**KIRKLEES METROPOLITAN COUNCIL
INVESTMENT & REGENERATION SERVICE**

Reference No:	2023/62/92597/W
Site Address:	John Shaw And Son Ltd, Canker Lane Garage, Leeds Road, Huddersfield, HD2 1XT
Description:	Change of use from B2 to Class E, Conversion of existing car garage to retail unit
Recommending Officer:	Lucy Taylor

Officer Report.

Proposal: Change of use from B2 to Class E, conversion of existing car garage to retail unit

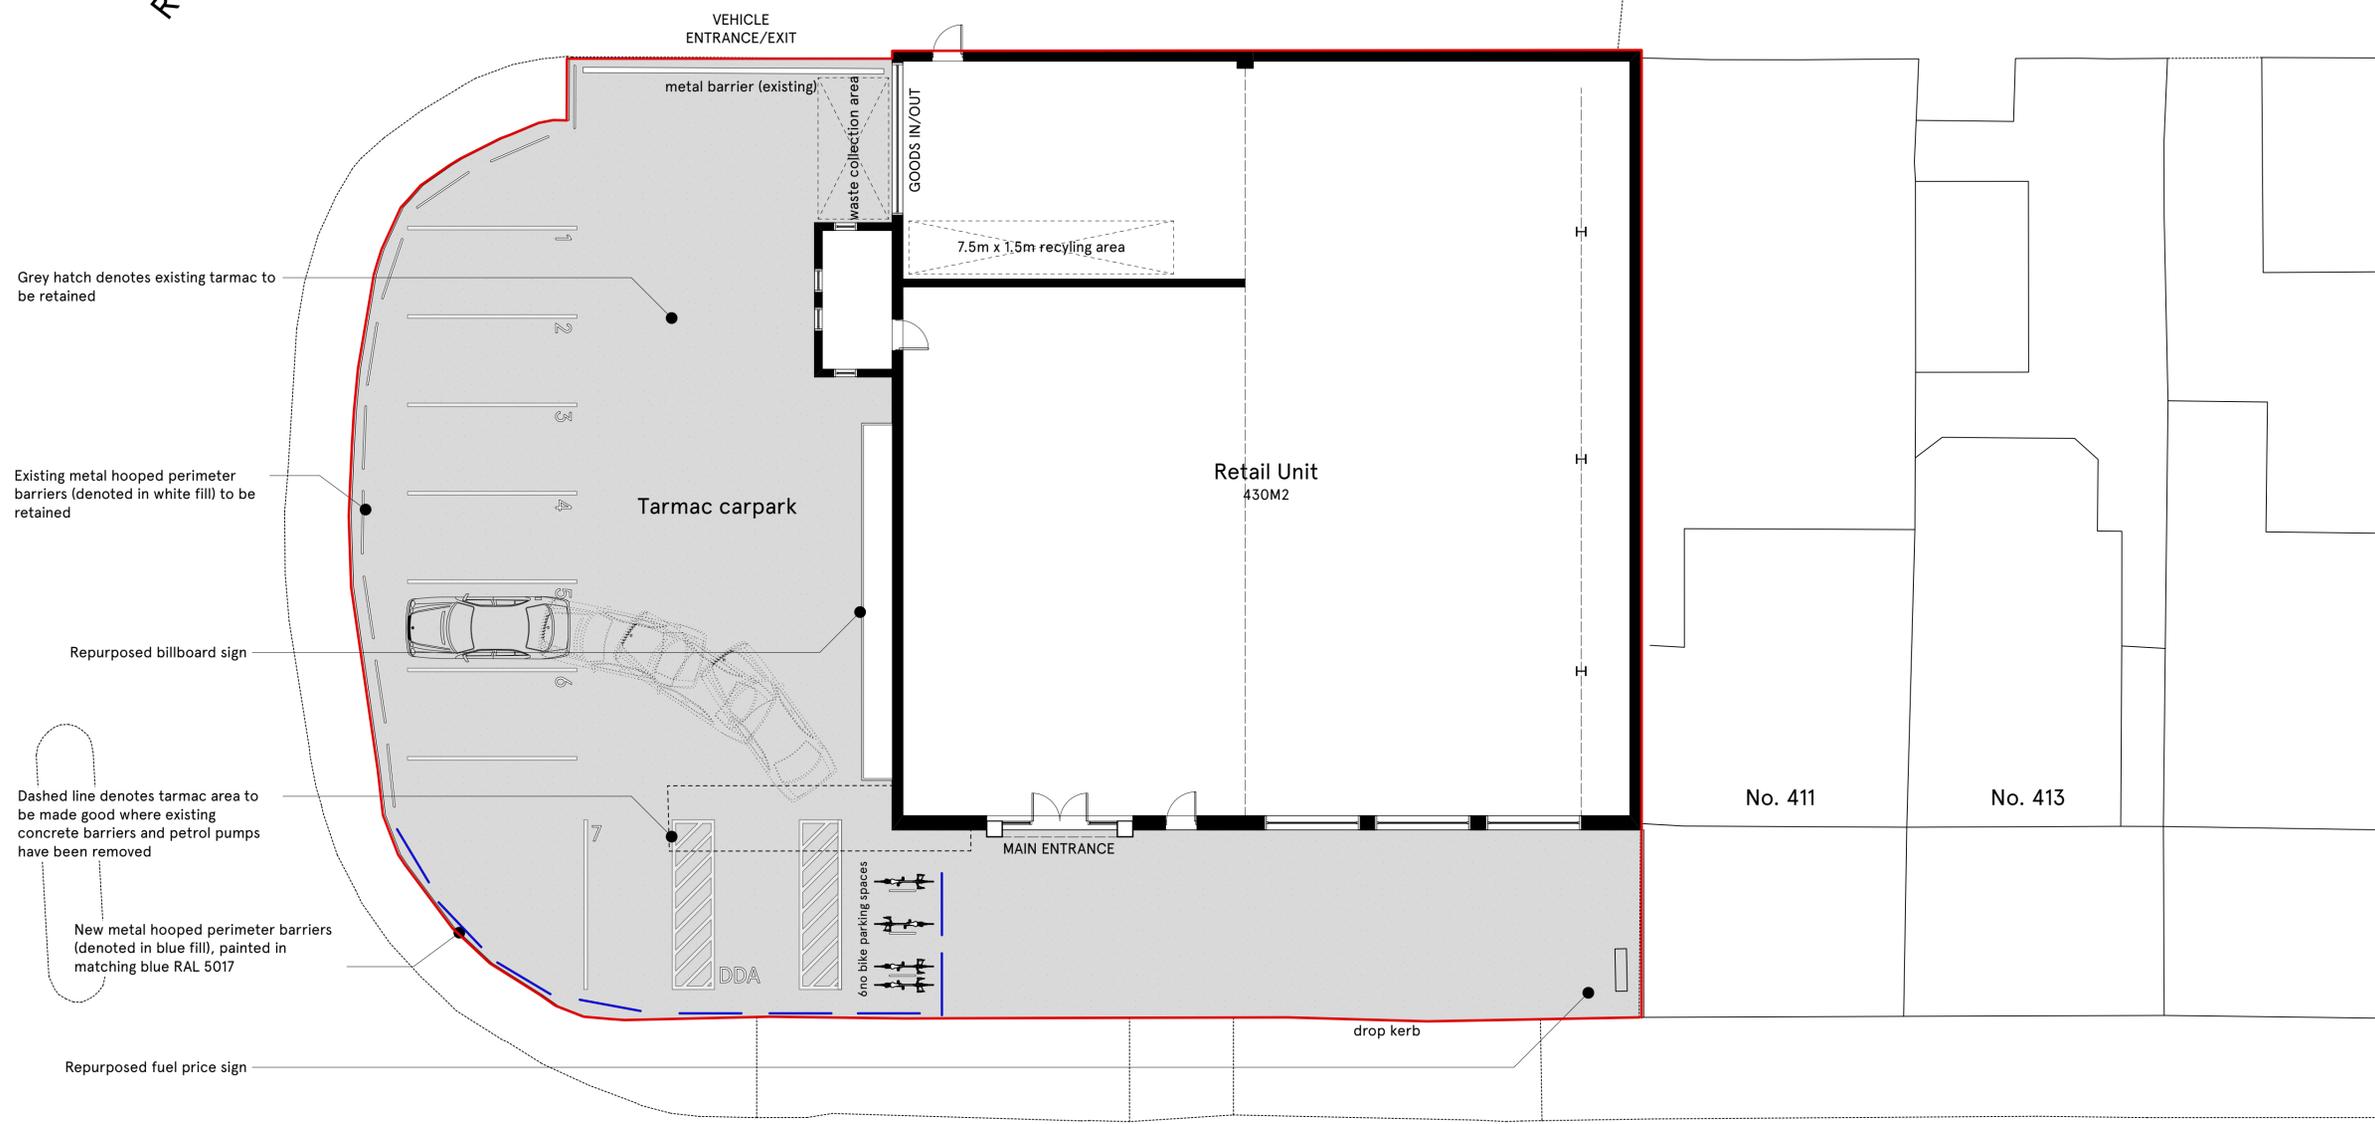
Drawing No A2000P1 shows the location of 7 standard 2.4 x 4.8m parking spaces and 1 accessibility space with some turning/manoeuvring space available. There is also cycle parking provided adjacent to the access. These are acceptable.

No details of waste storage and collection were provided within the application and these details should be conditioned prior to opening.'

1 Proposed (south) Elevation to Leeds Road  
Scale: 1:100

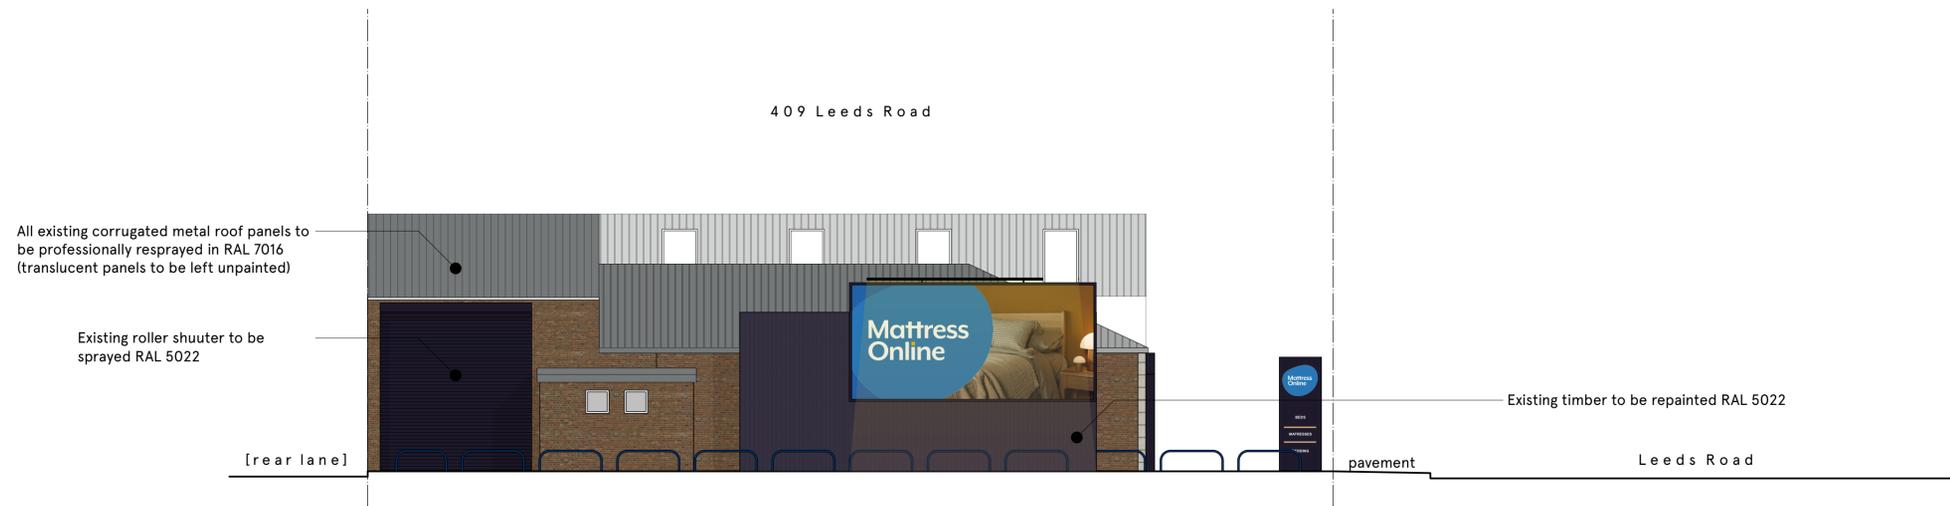
It does not appear as though the proposed Billboard sign to the western elevation (facing Red Doles Lane) formed part of the aforementioned Advertisement Consent application. As such, separate advertisement consent would be required for this.
